File: G23/0012
4500 Canyon Court NE
11/14/13 PE
Stamp.

COMMENT: DRAINAGE SWALE CALCULATION

**4500 CANYON CT., NE
GRADING AND DRAINAGE PLAN**

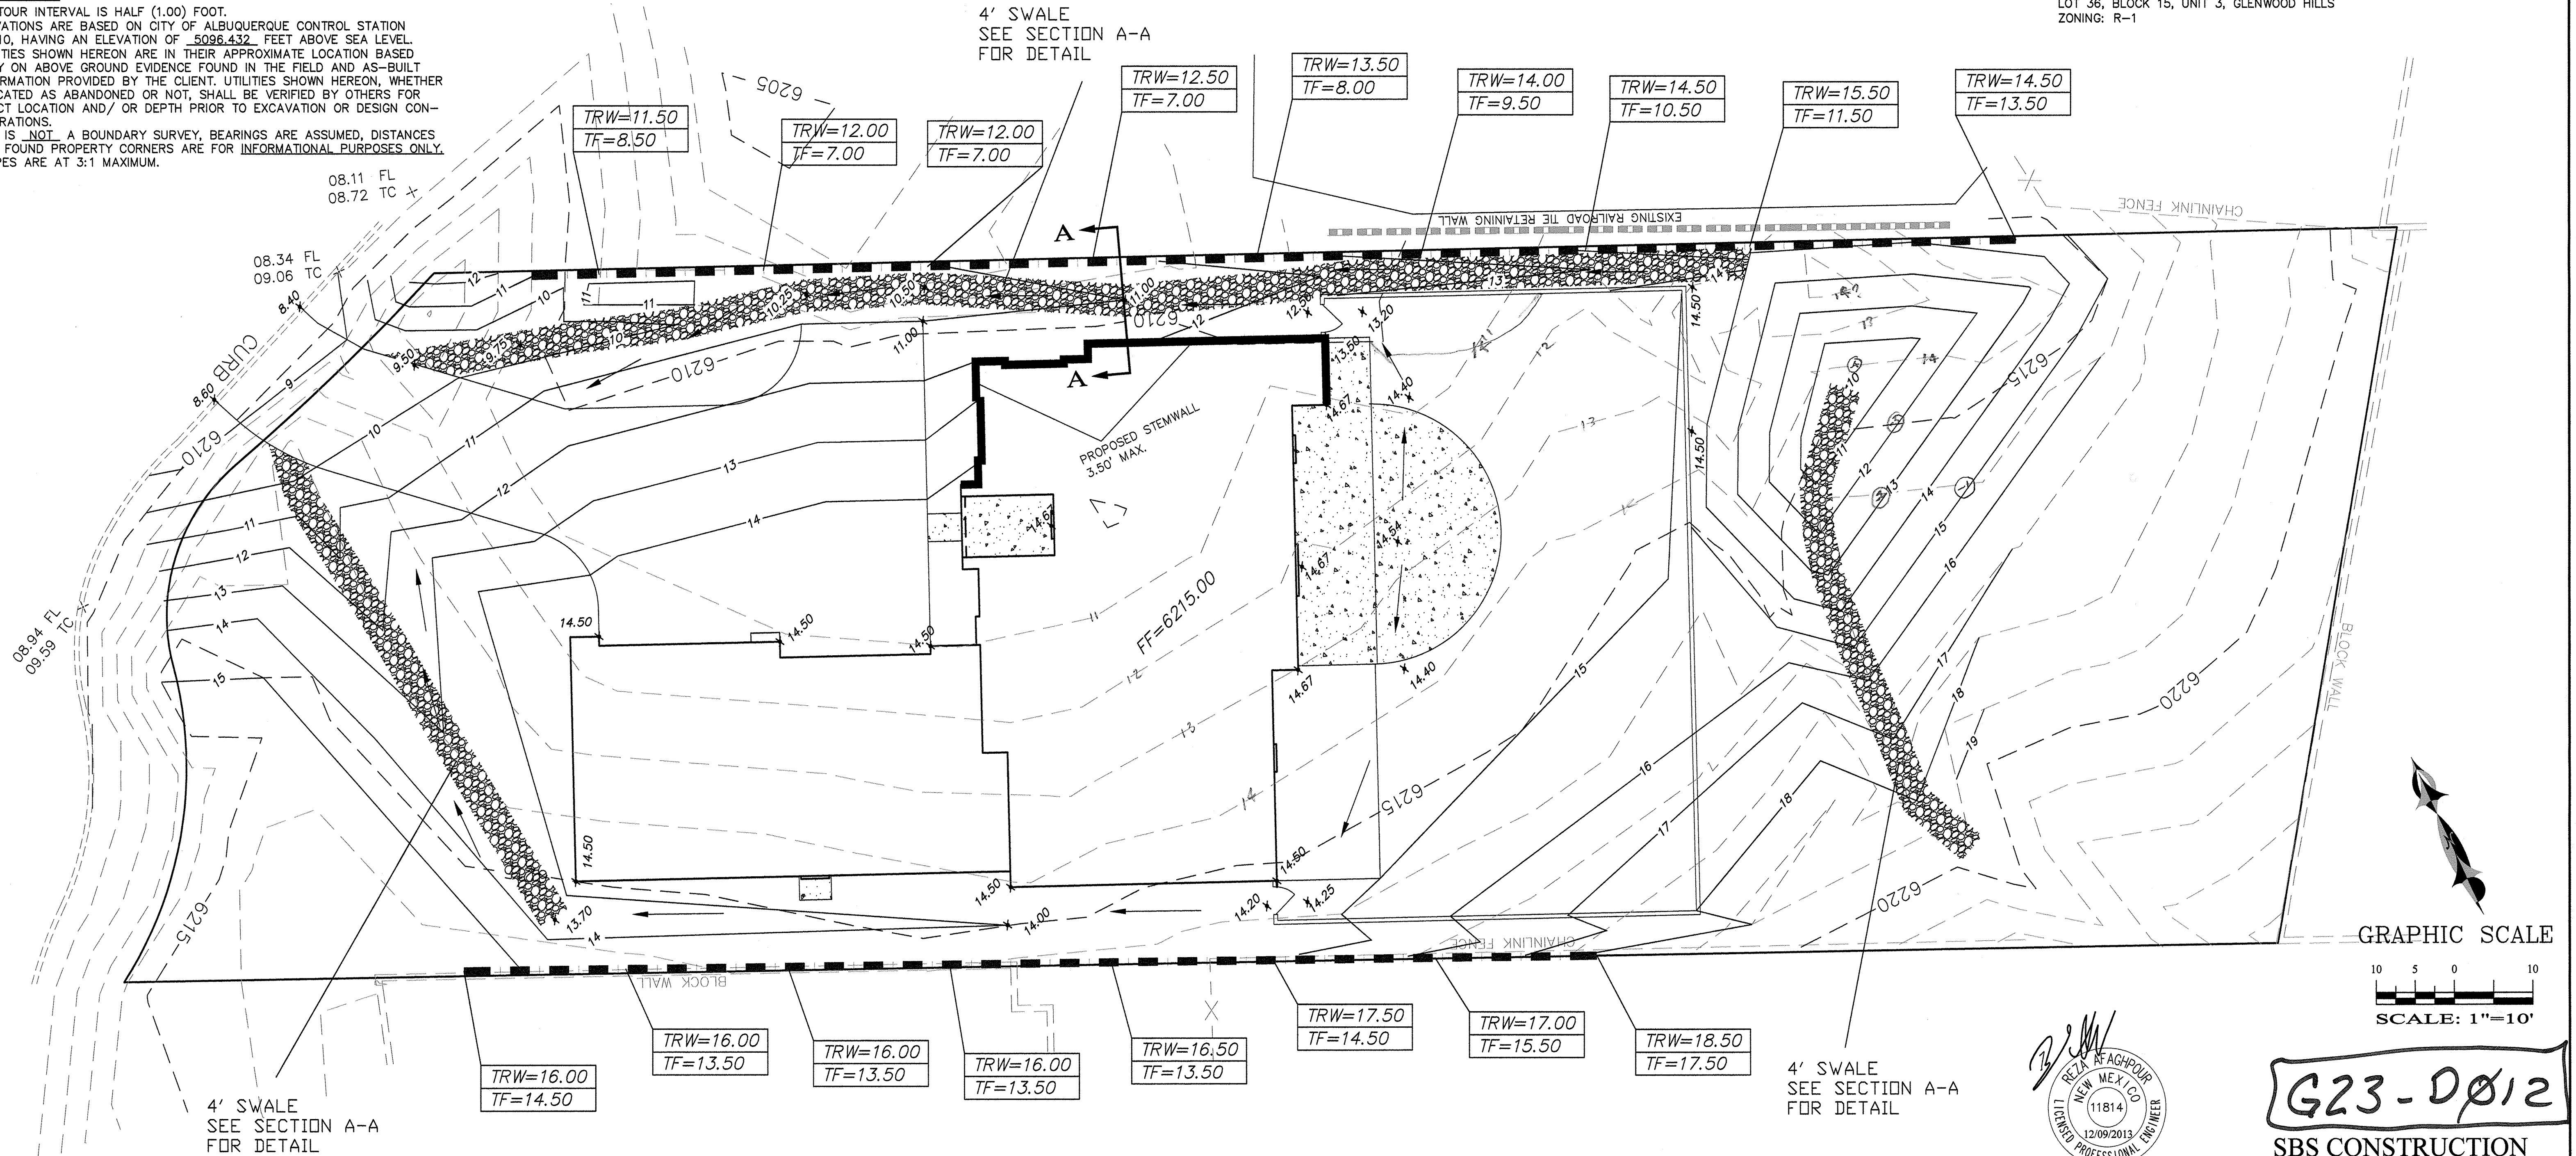
15.12 cfs passing through
0.018% min slope shown on plan

1' Depth shown on plan

Shown,
Please recalculate with
correct channel slope to
confirm that it will
contain the 15.12 cfs.

Email revised ditch calcs
& I can approve G&D.
